CITY OF ALBUQUERQUE

April 11, 2016

**Re: Sunset Villa Subdivision
Erosion Sediment Control Plan
Engineer's Stamp Date 3-30-16 (K12E003)**

Erosion Sediment Control Plan

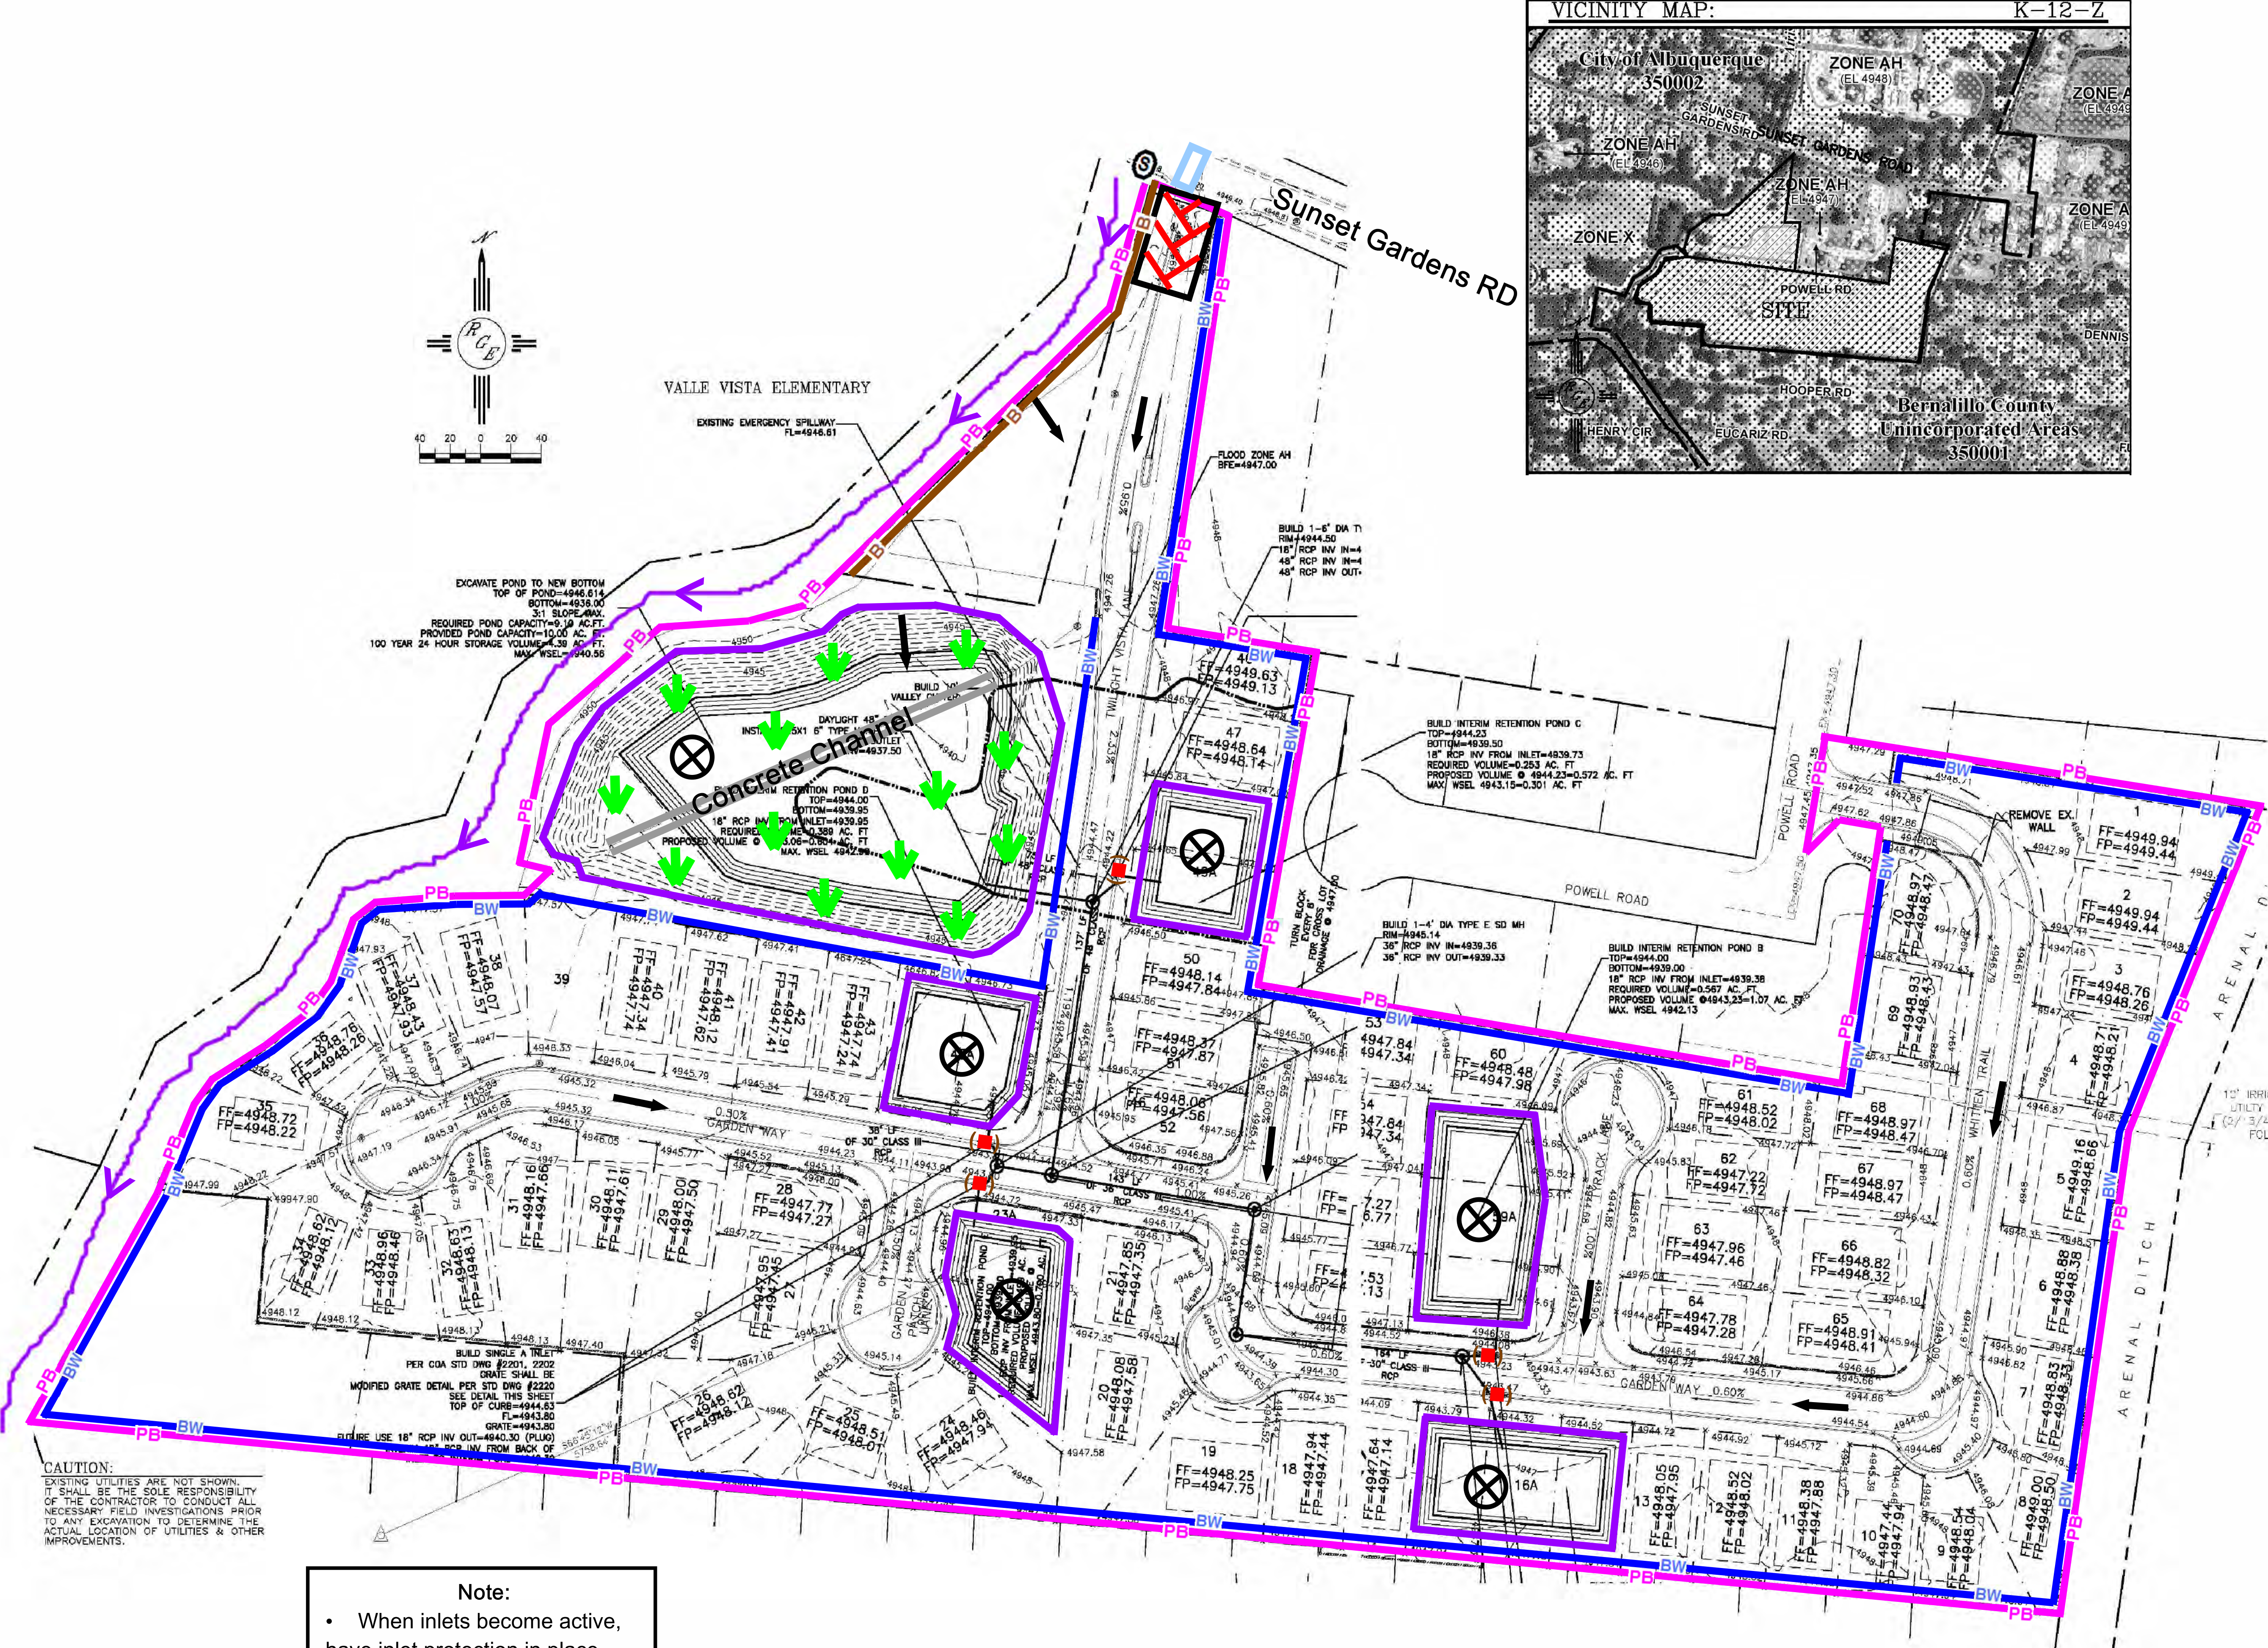
1. The project boundaries are not correct where the project ties into Powell Rd. Grading will occur to build the road connection to Powell Rd and a portion of an existing block wall in Powell Road ROW is to be removed. There also does not appear to be a wall across Whitten Trail at the north end as shown on the plan.
2. There appears to be a fence, not a block wall on the west side of the large pond.
3. For the water-line connection in Sunset Gardens Rd add a legend item and Keyed Note that the dirt should be placed on the uphill side of the street cut and the area swept after the work is complete.
